Consultation Response from KC, Conservation and Design		
2020/90371 3, Two Gates, Holme Lane, Slaithwaite, Huddersfield, HD7 5UG		
Listed Building Consent for partial demolition of existing dwelling and erection of replacement dwelling		
Date Responded:	Responding Officer: Craig McHugh	Responding Ref: CV 5/169

Drawing number
1106 (PL) 03

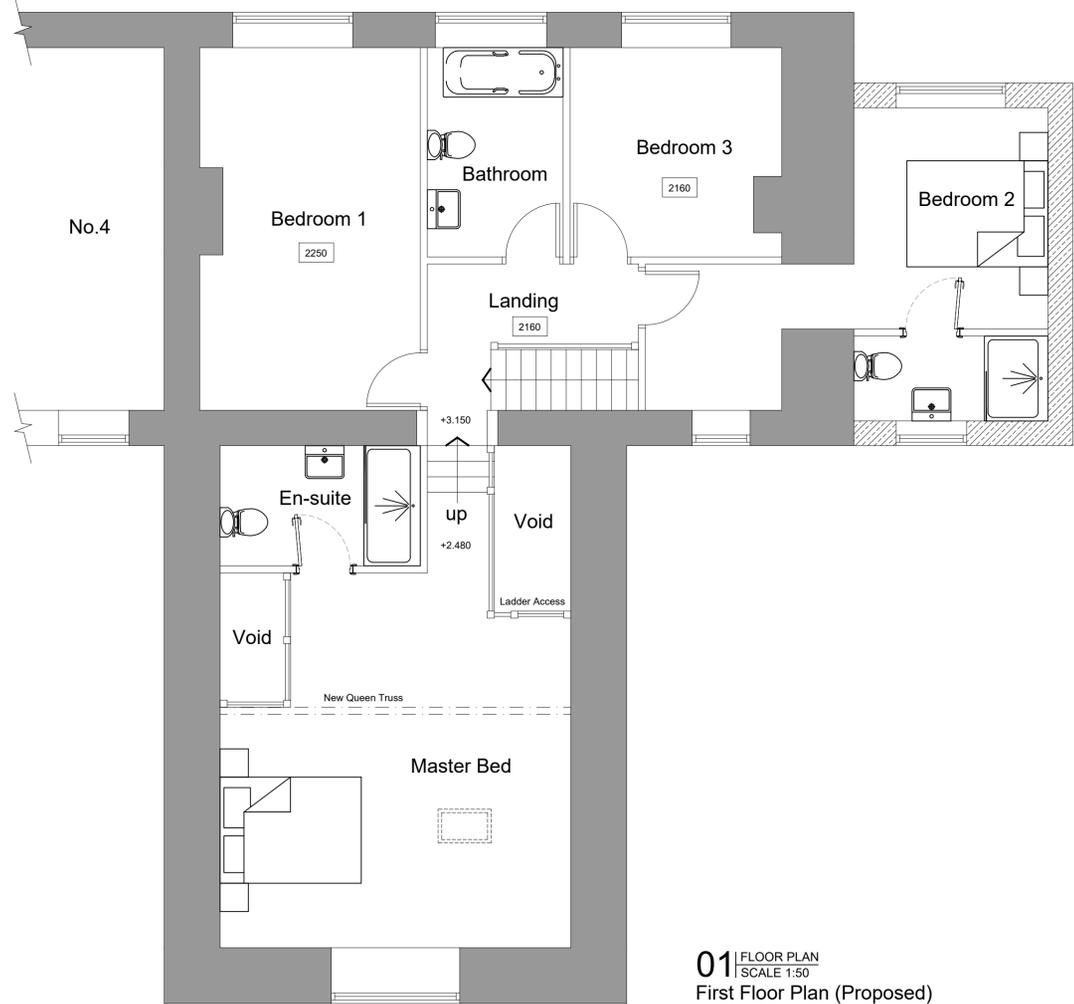
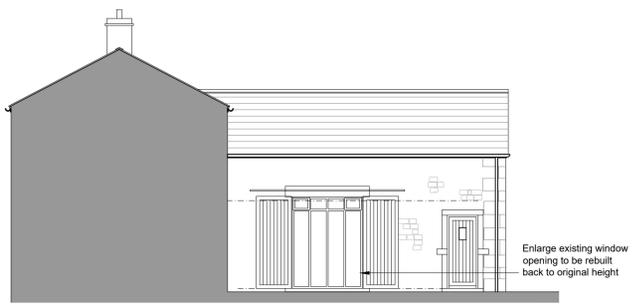
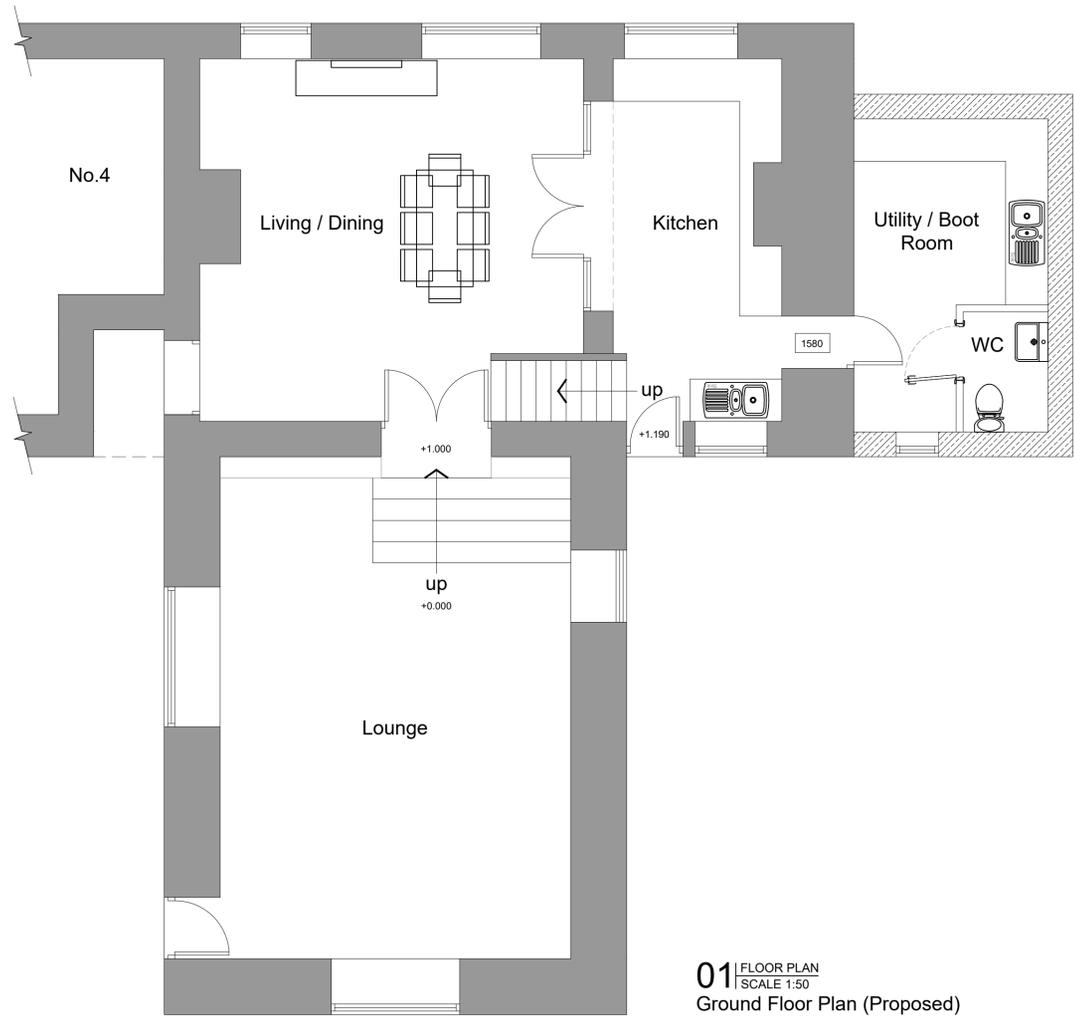
With regards to the barn, the alteration of the window on the north east elevation into a full height opening would be an enhancement and better reveal the original function of that part of the building. The levelling of the ground floor, the insertion of a floor across most of the remaining barn space, the loss of the hayloft and stairs and the replacement of king post truss with a queen post truss would be harmful. The original floor levels were retained and the king post truss, hay loft and staircase were purposefully replaced like for like in the same locations as part of last conversion c.1995 to preserve the original design of the barn.

The existing lean-to is of some interest with its vaulted ceiling, but it has been heavily altered and is in a poor condition. The design of new extension is acceptable, the gable window should however be omitted from the extension. Subject to this minor amendment these works will have a neutral impact. The outer skin of the gable elevation should be reconstructed in masonry to match its current appearance, including the blind window near its apex. It is accepted that this feature will be mostly hidden from view but this would make the extension reversible in the future and better preserve the features of the building.

The proposed internal alterations would cause harm to the significance of the listed building by altering its layout and design. Proposals are required to retain the ceiling beams to the farm house. There may be some scope for additional accommodation at first floor in the barn, however the differing ground floor levels, king post truss and the existing layout replicating the hayloft and its staircase should be retained.

Proposals for the alteration of the barn need revisiting to retain the original floor levels, king post truss, hay loft and staircase.

Drawing
**Details of proposed first floor &
 section detail of new internal wall**

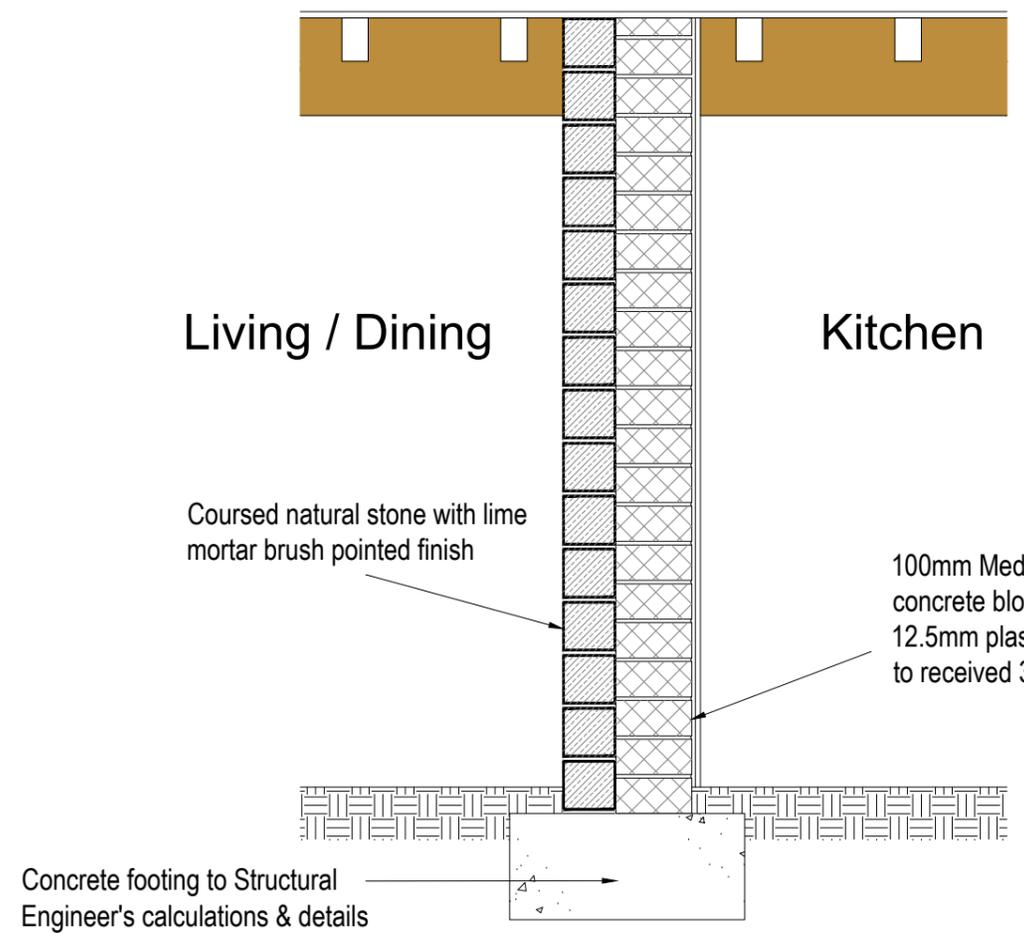
Details of the proposed new first floor structure/ ground floor ceiling to the farm house are required showing how the original ceiling beams will be retained. A section drawing should also be provided of the new wall between the kitchen and Dining/ Living Room. At least part of the load bearing wall should be reinstated to support the ceiling beams and to illustrate the original layout of the listed building.

Window Details

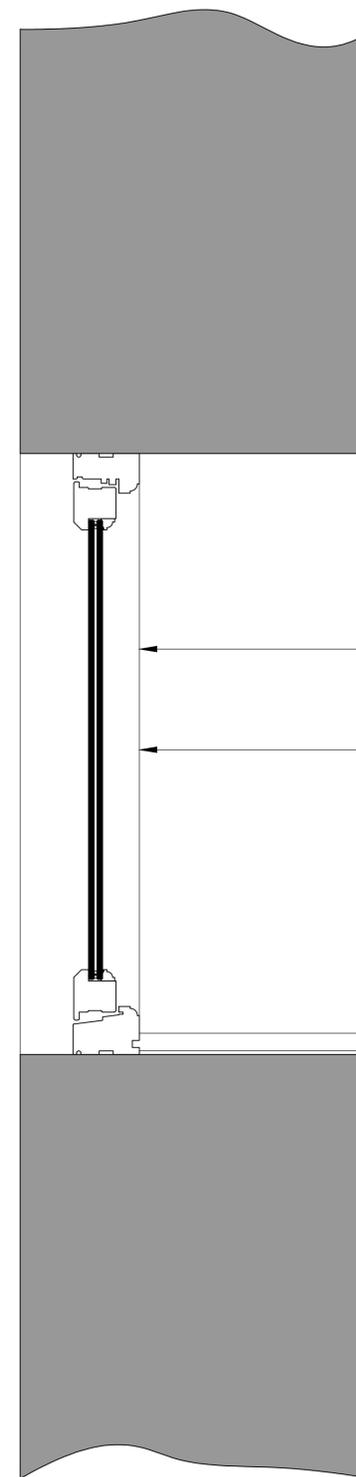
No details have been provided for any replacement windows, which will likely be required once the front elevation has been rebuilt.
